DEVELOPMENT REVIEW BOARD  
TRANSPORTATION DEVELOPMENT

DRB Project Number: 1011331  
Alvarado Gardens Unit 1

SUBJECT: Preliminary/ Final Plat, Sidewalk Variance

DRB Project Number: 1011331 Hearing Date: 3-14-2018  
 Project: Alvarado Gardens Agenda Item No: 11

PLAT OF TRACT 1-A-1, TRACT 1-B-1, AND TRACT 1-B-2 ALVARADO GARDENS UNIT 1

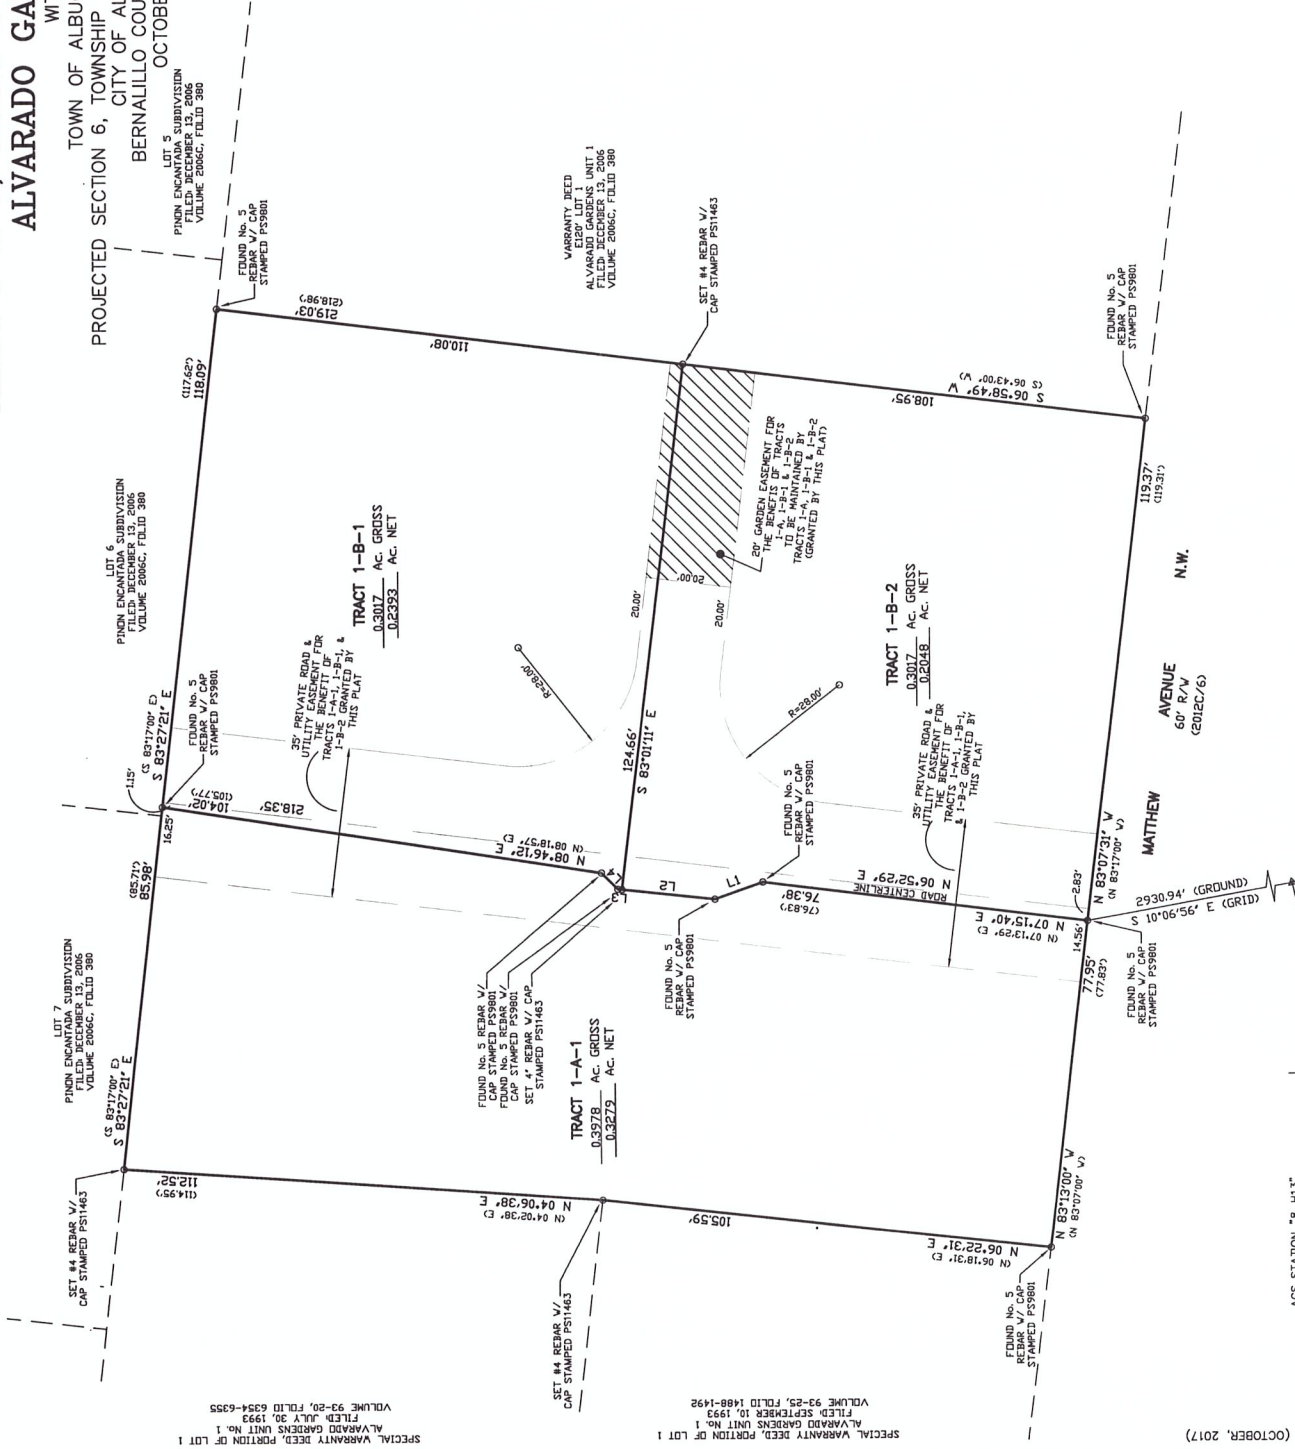
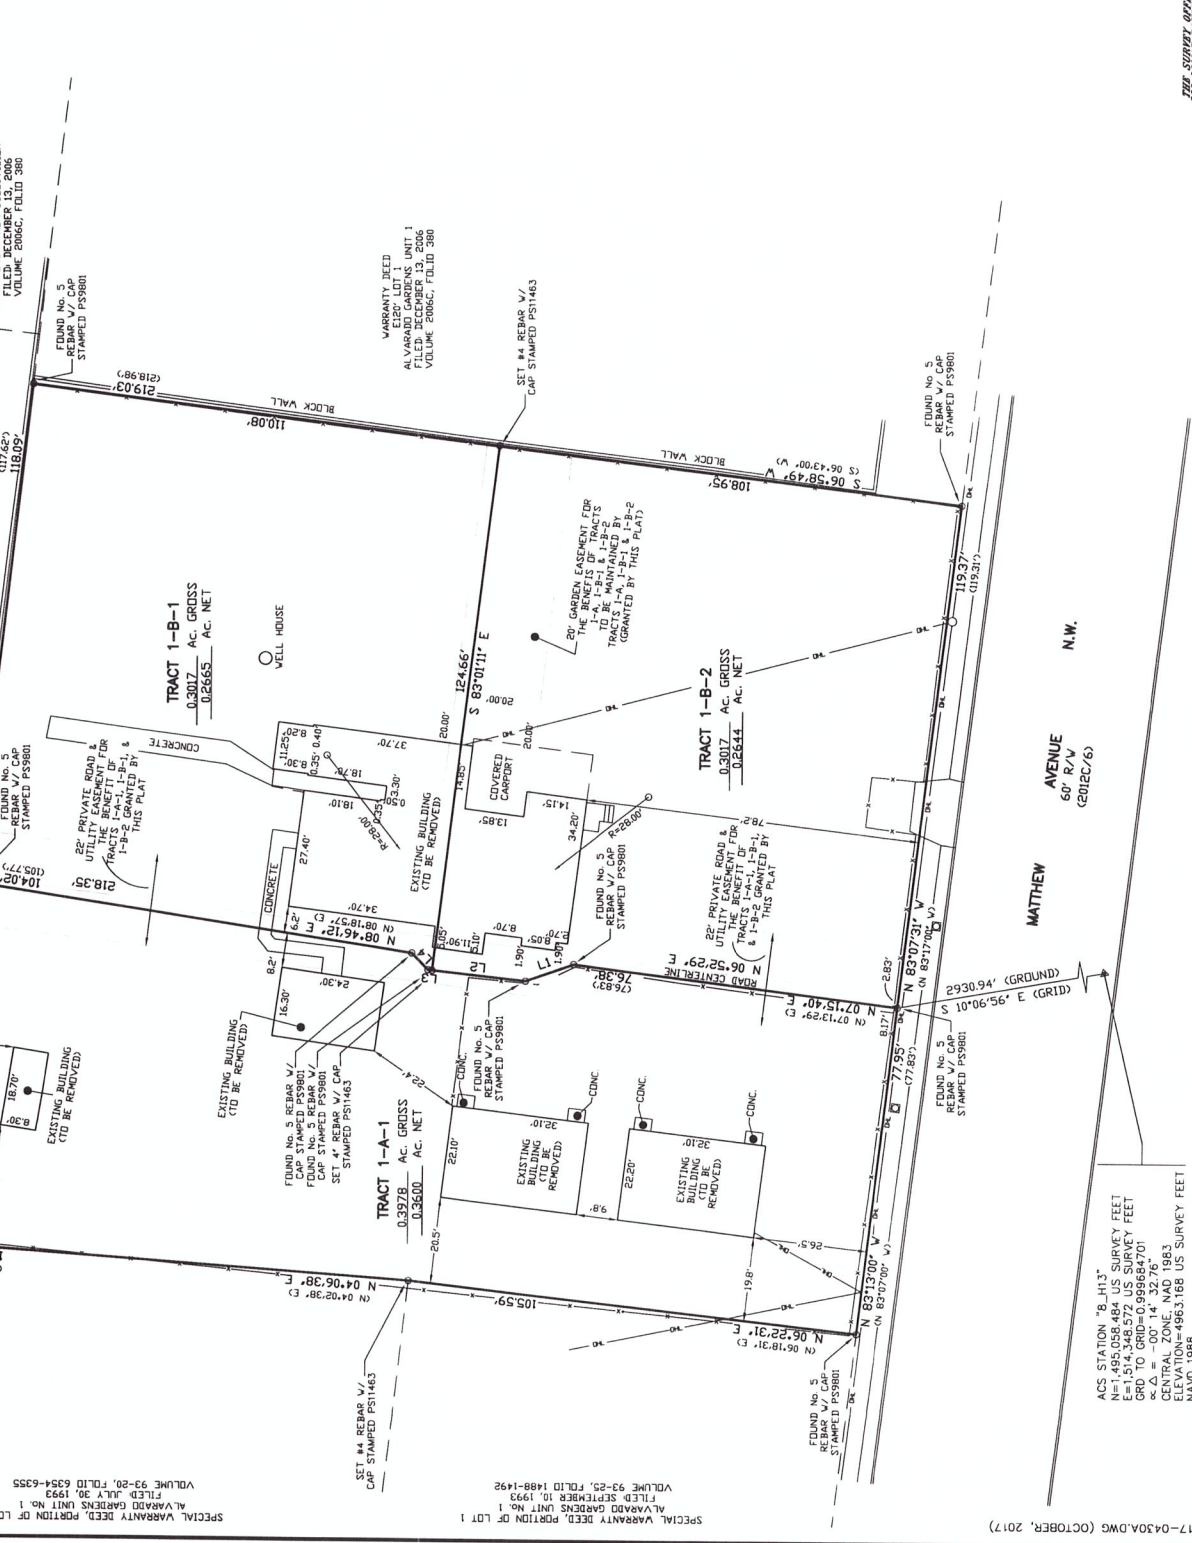
- The blanket cross lot drainage easement will need to name the affected lots and the beneficiaries.
- The SIA will need to be recorded.
